Date: 02-Mar-2022
Our Ref: 2021/93078

**Discharge of conditions 3 (materials), 5 (cycle parking) & 7 - 11 (contamination & coal mining legacy) 12 (noise) on previous permission no. 2019/93483 for Erection of 4no. A1/A3 ground floor units, 3no.B1 offices and ancillary space, a free standing ATM and car park
adj, 17, Hillhouse Lane, Fartown, Huddersfield, HD1 6EF
Application Number: 2021/93078**

Site And Location Plan

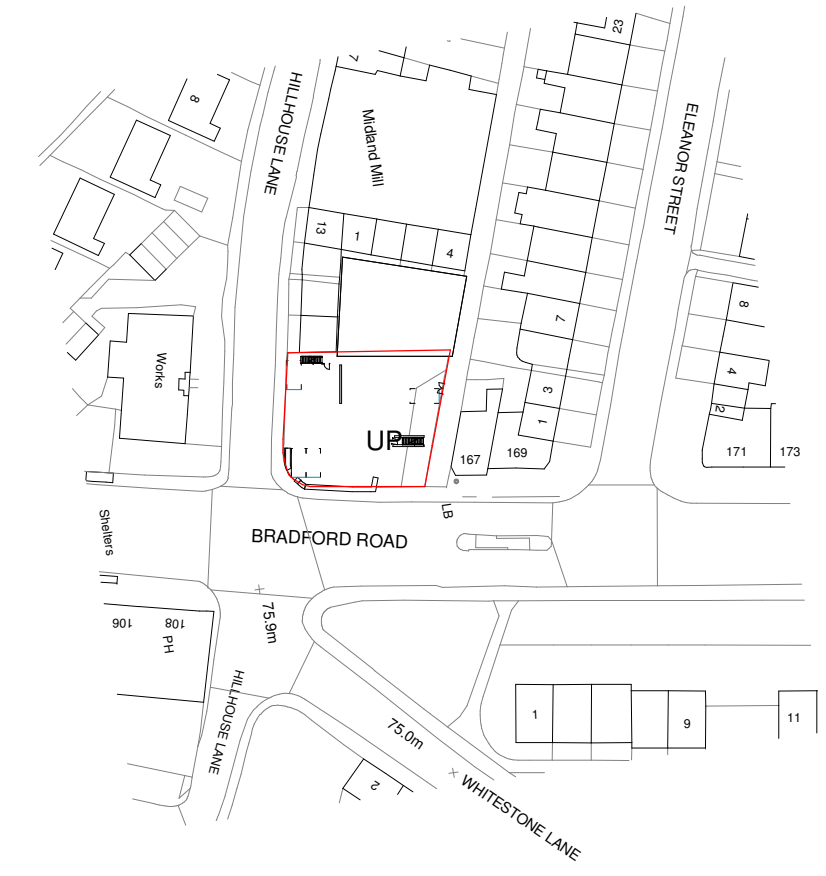
The submitted detail sets out that 2 Sheffield hoop bike stands would be provided, as set out on a plan by Hudds Design and received on 2 August 2021. The stands could accommodate up to 4 bicycles adjacent to the pedestrian access to the site that leads from

the footway off Bradford Road. The Highways Officer has advised that although the stands are acceptable, some of the stands appear to be placed on grass verge.

The provision of these stands is therefore considered acceptable provided the area around the stands where the bicycles are to be parked is hard surfaced prior to use and retained thereafter.
